**Consultation Response from KC, Highways Development Management (HDM)****2025/92776 land at, Eastfield, Shepley, Huddersfield, HD8 8HB****Outline application, with all matters reserved, for residential development with associated open space, landscaping, drainage infrastructure and associated works****Date Responded: 26/03/26 | Responding Officer: A.Darwin | Responding Ref: 12-39/22****RECOMMENDATION:**

Figure 4-2 Knowle Park Avenue Proposed Southbound only arrangement

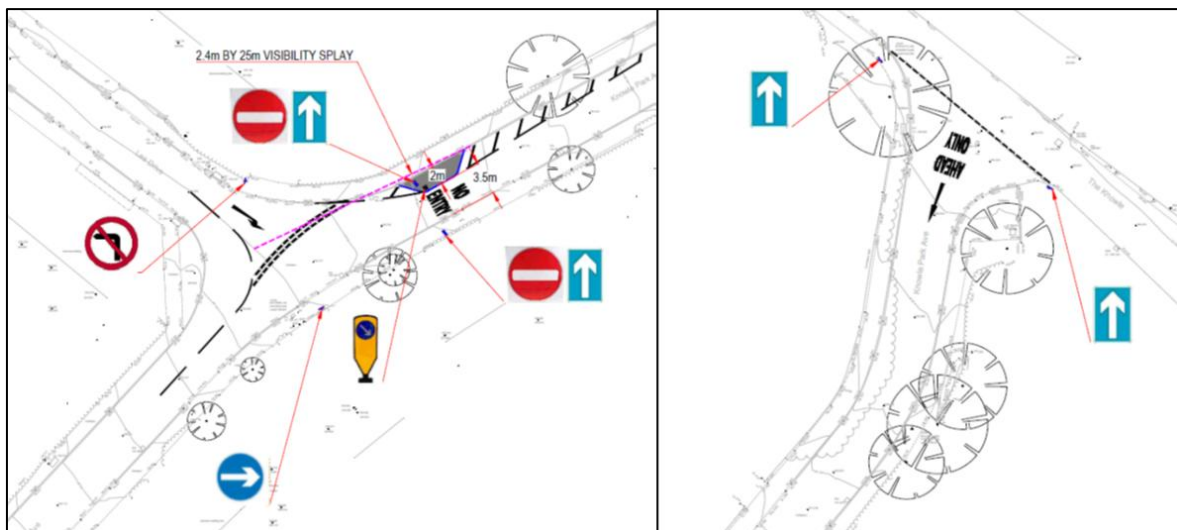
The applicant has now proposed a one-way system on Knowle Park Avenue. However, this has been proposed in the opposite direction to that suggested by HDM. The rationale provided by the applicant for this, is due to their view that there is restricted visibility at the Knowle Park Avenue / The Knowle junction. HDM have checked the visibility splays at this junction based on the topographical survey information provided with the submission. This indicates that visibility splays in excess of 2.4x28m (measured to the nearside wheeltrack position) are available at the junction, which are adequate based on the recorded speed data provided in the TA (19-22mph at ATC 2 and ATC 3). Therefore, the applicant's rationale for providing the one-way route in the southbound direction is not accepted by HDM.

Notwithstanding the above, it is now apparent that there are significant local concerns regarding making Knowle Park Avenue one-way (these concerns would be valid, whichever direction a one-way system was proposed). The most significant concern that has been raised relates to the potential impact of the proposal during icy/snow conditions, due to the steep gradient on the initial section of Lea Drive (up to 1:8 based on the submitted topographical survey data). Local residents have highlighted that snow / ice can make Lea Drive unusable for many people during these adverse weather conditions, with residents needing to use the less steep (circa 1:16) route via Knowle Park Avenue instead. HDM acknowledges these local concerns and agrees that the one-way proposal (in either direction) should not be pursued.

As the Knowle Park Avenue one-way proposal is not an acceptable option, it is considered that the development should instead contribute towards alternative measures, to enable the increase in development traffic via The Knowle to be accommodated, ensuring that safe and efficient operation of the route is maintained following development. However, as existing traffic flows along The Knowle are currently relatively light, and as no personal injury accidents have been recorded on this section of highway within the last 5 years (as confirmed in the TA), it is considered that any mitigation measures are best determined following full occupation of the development, should they become necessary. Therefore, to enable future mitigation measures to be delivered, a Section 106 of contribution of **£50,000** should be provided by the development. This contribution has been agreed as being appropriate with the Council Highway Safety Team, and is commensurate with the likely costs that would have been incurred in delivering a one-way scheme, thus enabling mitigation works of a similar scale to be delivered, if necessary. These works could include signing / lining works, footway improvements, new/amended TRO's or other appropriate works identified in future by the Highway Safety Team. It is suggested that this contribution would need to be retained for a period of 5 years following full occupation of the

Drawing:
PROPOSED HIGHWAY IMPROVEMENTS - LEA DRIVE / ABBEY ROAD JUNCTION

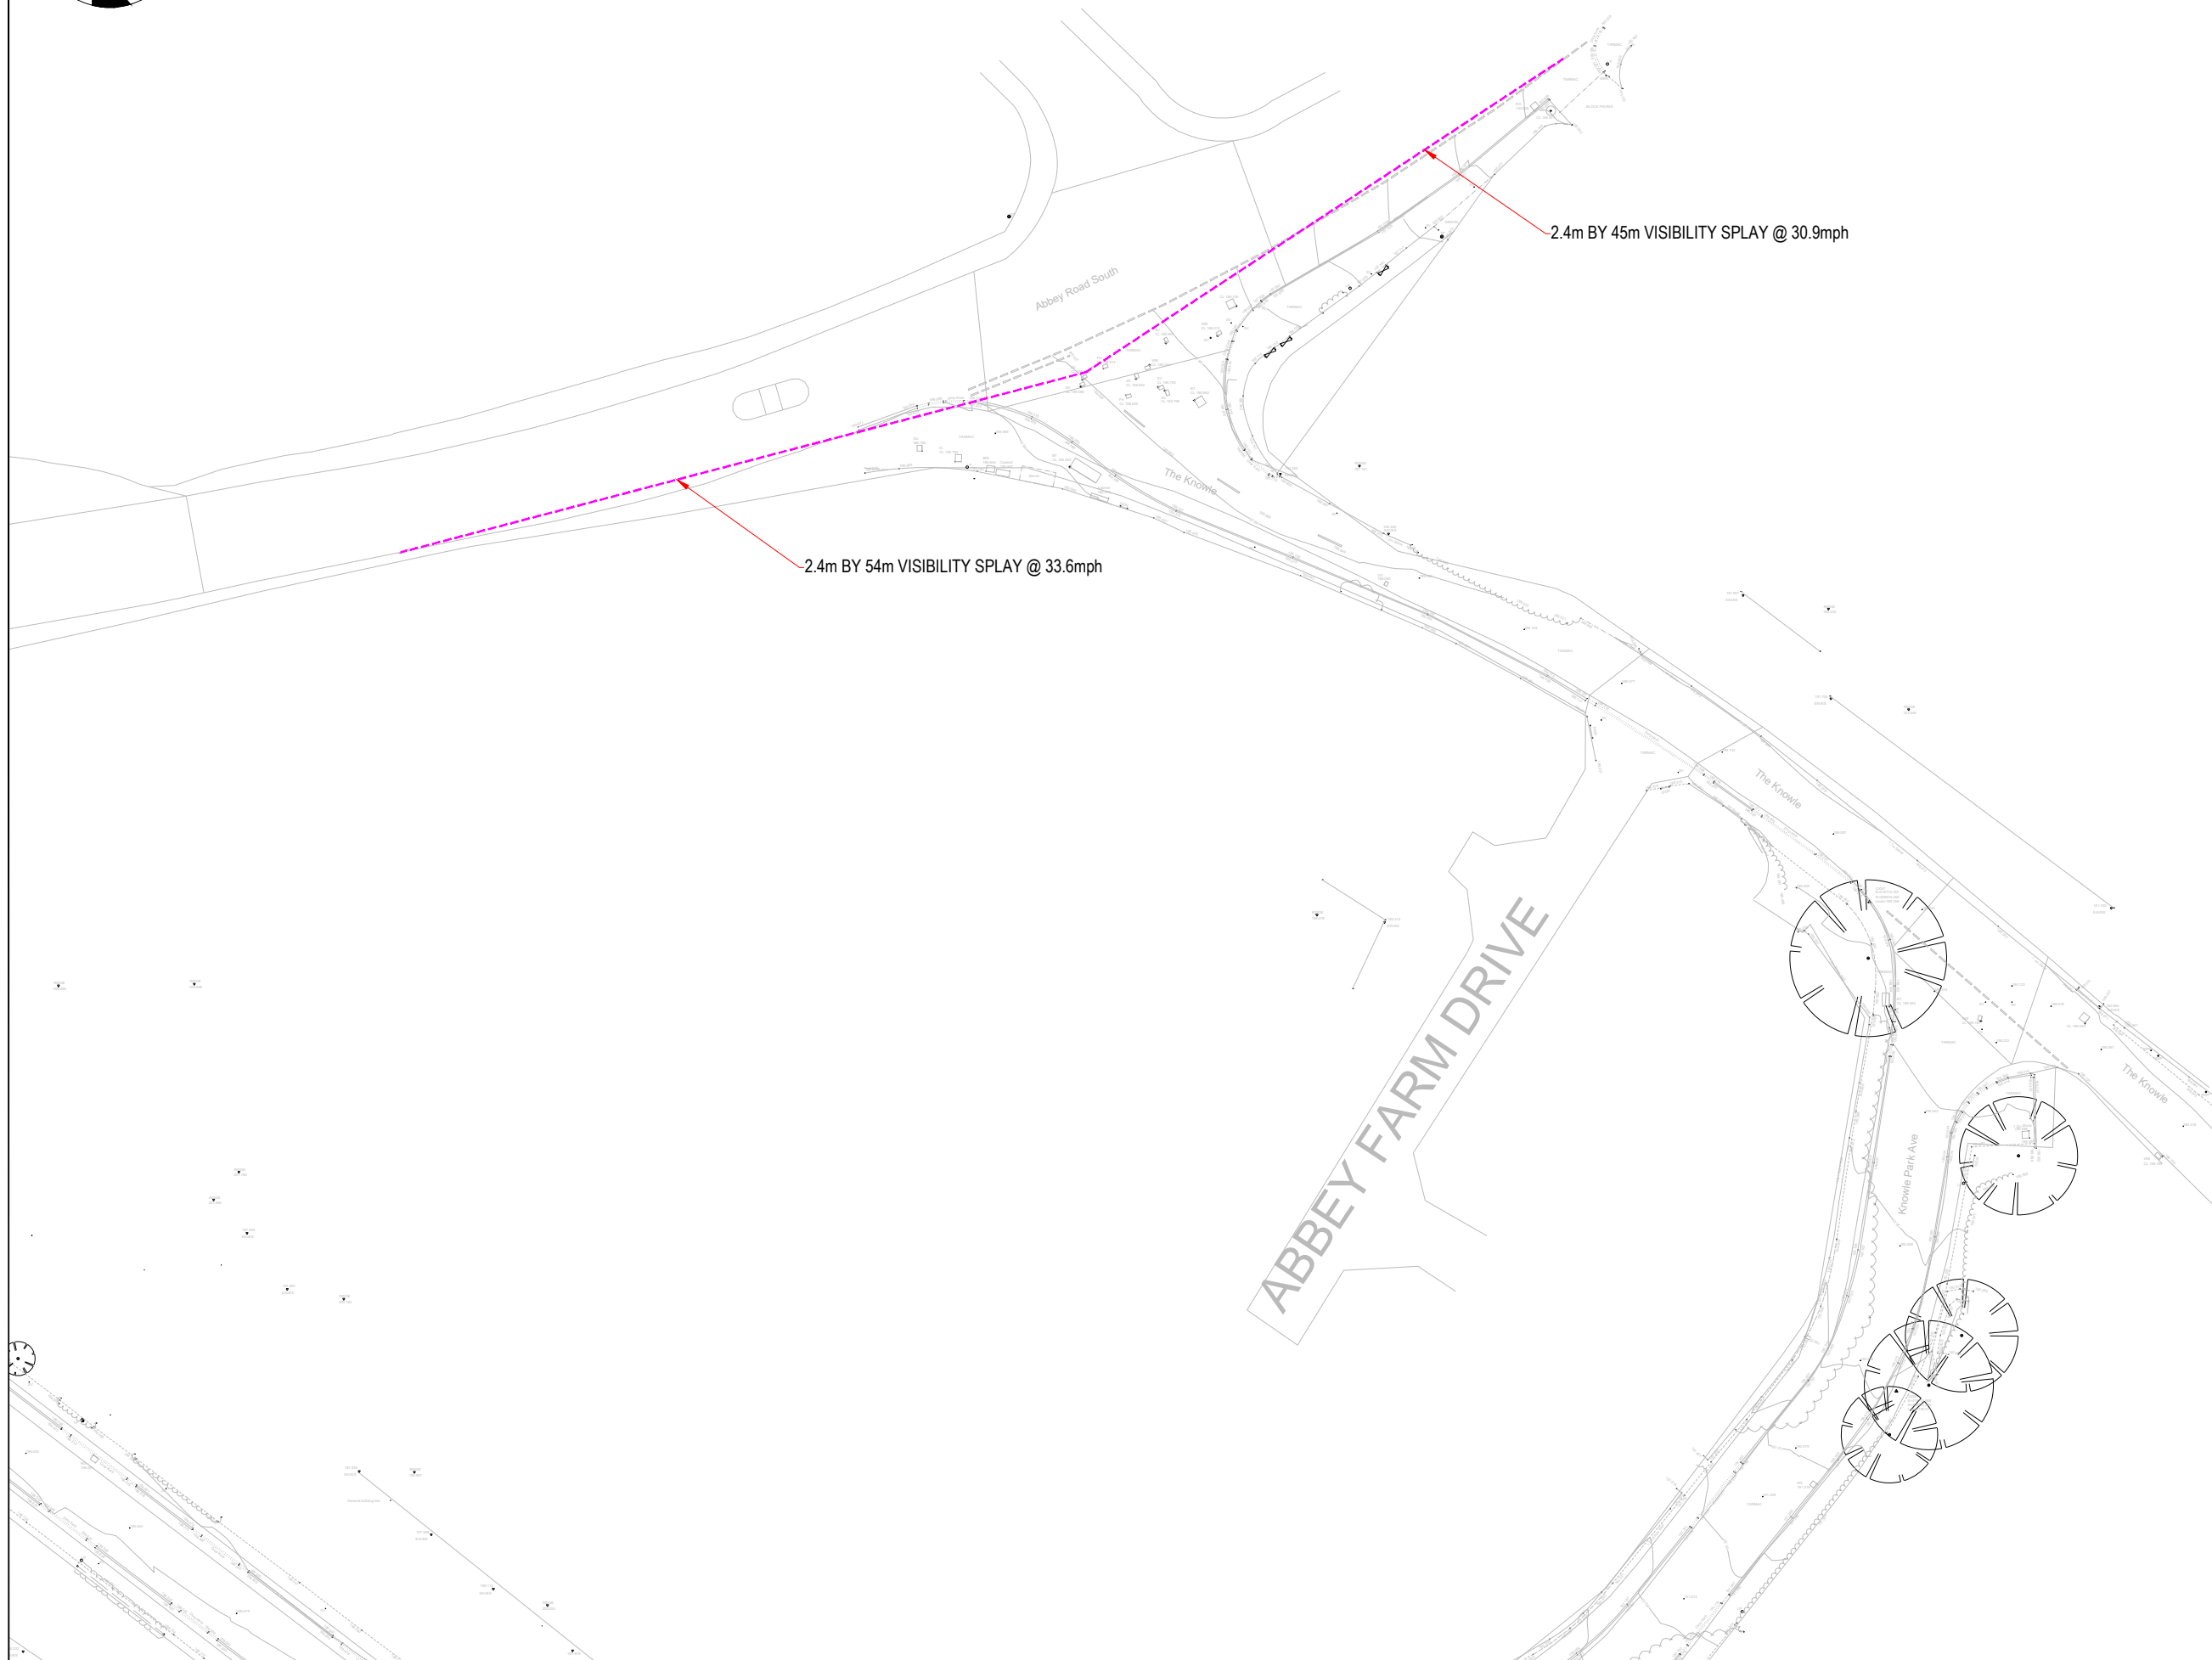
Based on HDM site visit observations, the visibility splay looking to the southwest of the Lea Drive junction towards northeastbound traffic on Abbey Road is often obscured by parked cars associated with the adjacent properties, and to a lesser extent by school related traffic. This could be fully addressed by extending the proposed DYL on the initial section of Lea Drive, so that the DYL's extend along Abbey Road in front of the adjacent dwellings. However, given that no turning related collisions have been recorded at the junction (as confirmed in the accident analysis in the TA, there have been no recorded PIA's at the junction in the last 5 years of any type) and as parking restrictions would be detrimental to the amenity of the existing occupiers of these properties, it is not considered necessary to introduce extensive DYL within the vicinity of the junction at this time. That said, the indicative DYL proposals shown on drawing AMA-23174-SK-006 P02 should be extended slightly to cover a 10m length either side of the junction (measured from the projection of the minor arm e.g. 2-3m further than currently shown) and for the same length on the opposite side of the junction. A bar marking (circa 5m long) should also be indicated in front of the dropped vehicle crossing for No. 219 Abbey Road, located immediately southwest of the proposed DYL markings, to prevent parking from blocking the access, and further discouraging parking within the immediate vicinity of the junction. These indicative DYL / bar marking proposals should be finalised once the junction modelling has been updated (see further comments below) and the peak queuing information has been confirmed. However, based on the junction modelling information provided to date, it is not expected that any additional changes to the DYL proposals would be necessary.

The above DYL and bar markings will assist by ensuring junction visibility is not significantly constrained by parked cars following initial occupation of the development, but with limited impact on existing highway users (e.g. as the suggested DYL proposals only reinforce general parking prohibitions that already exist in line with the highway code). However, should visibility (or other) related issues arise in future that require remedial works, there would be scope to increase the DYL restrictions (or other appropriate works) in future, by utilising the aforementioned *'Off-site highway works contribution'*.
